# CITY OF ALBUQUERQUE

September 14, 2020

**Re: Lot 21-A Block 2 Unit 19 Volcano Cliffs, S.A.D. 228  
7704 Compass Dr. NW  
Request for Permanent C.O. – Not Accepted  
Engineer's Stamp Dated: 12-10-2020 (D10D003G21A)  
Pad Certification dated: 1/14/2019  
CO Certification dated: No Date**

ASBUILT SURVEY

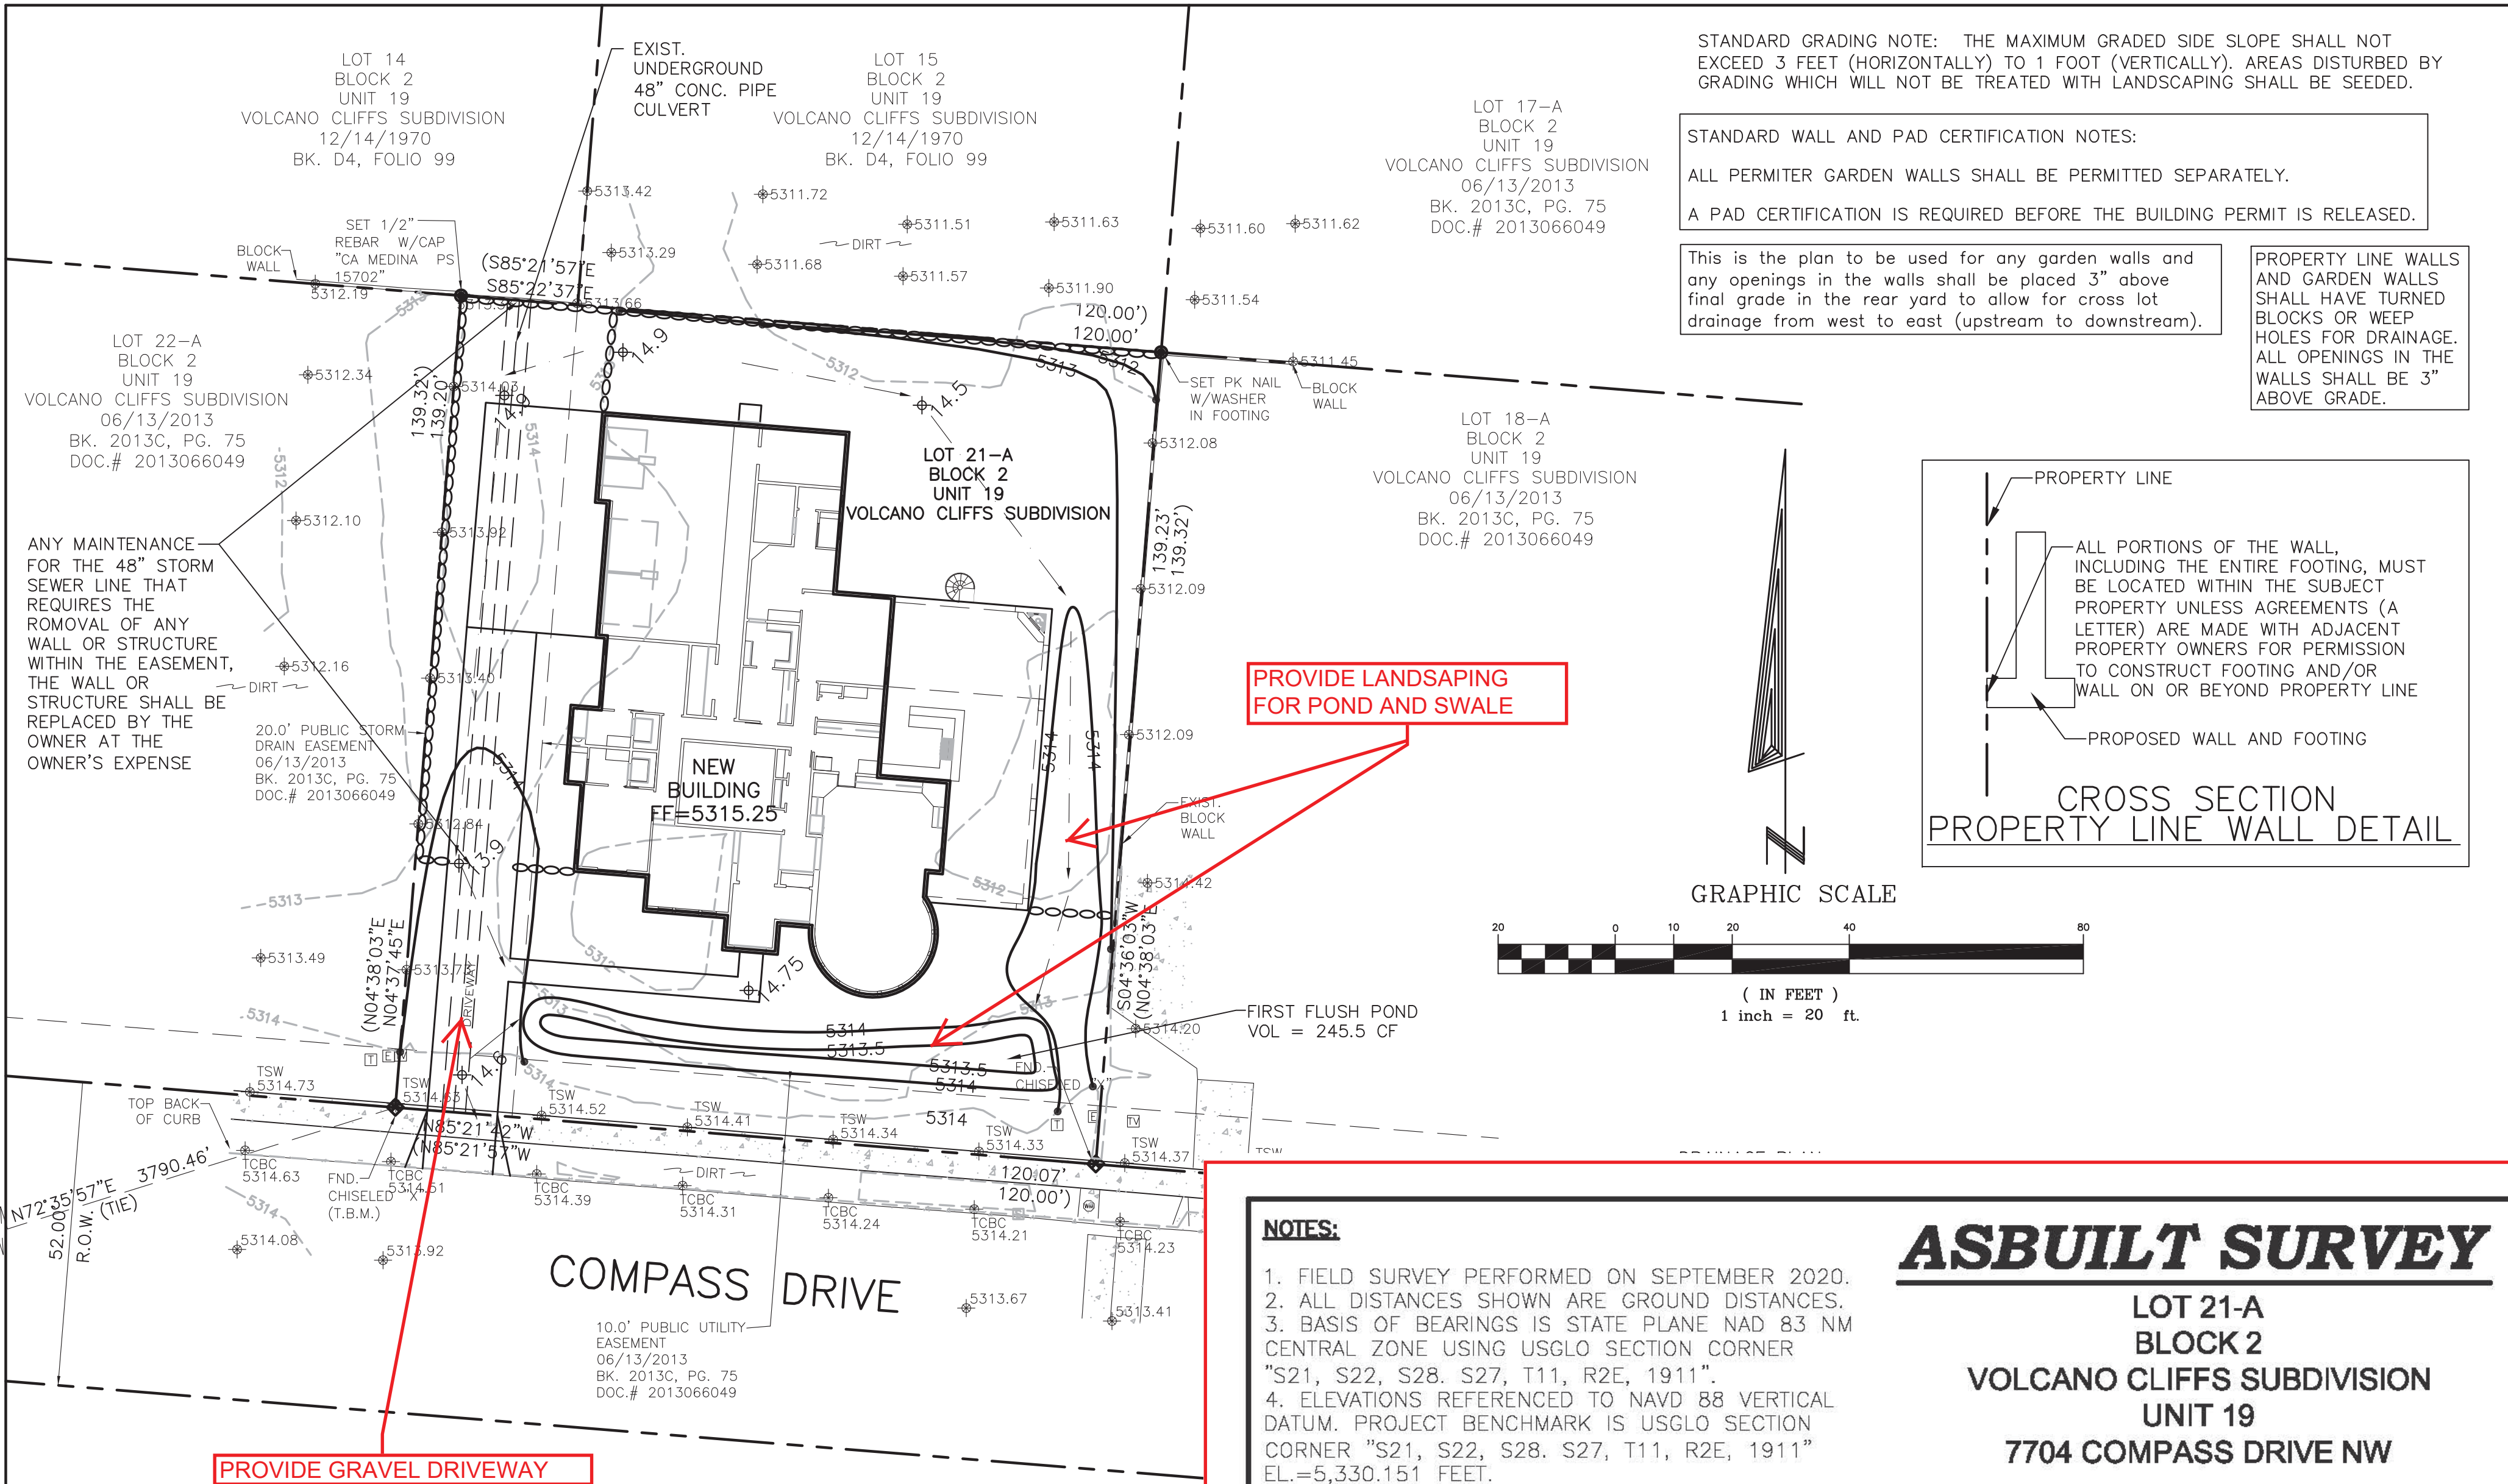
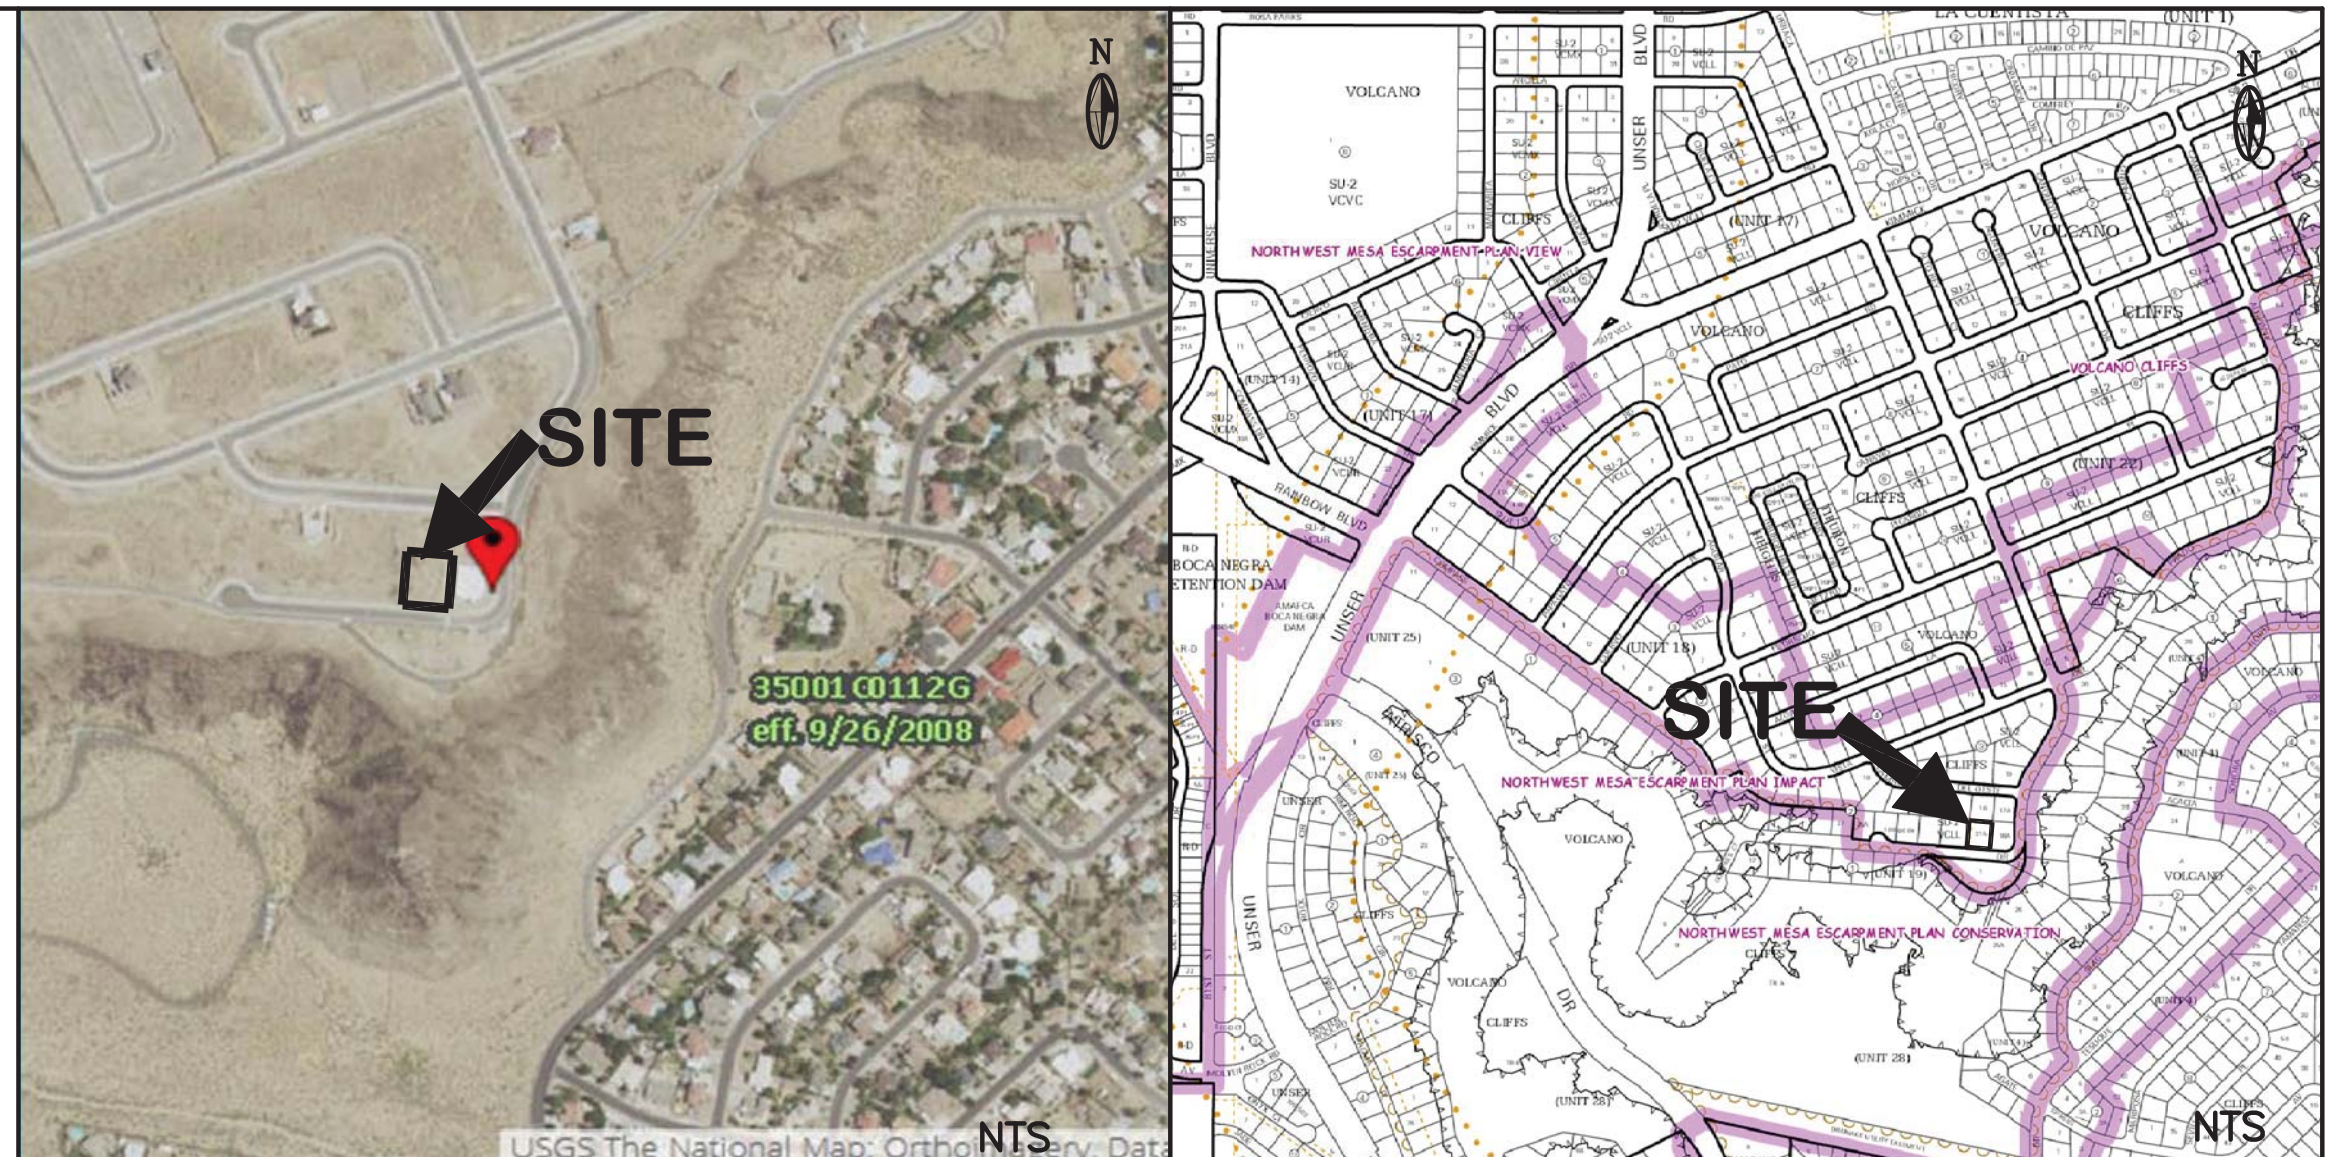
- Provide a signature and date for the CO.
- Provide landscaping for ponds and swales.
- Provide the drive pad.
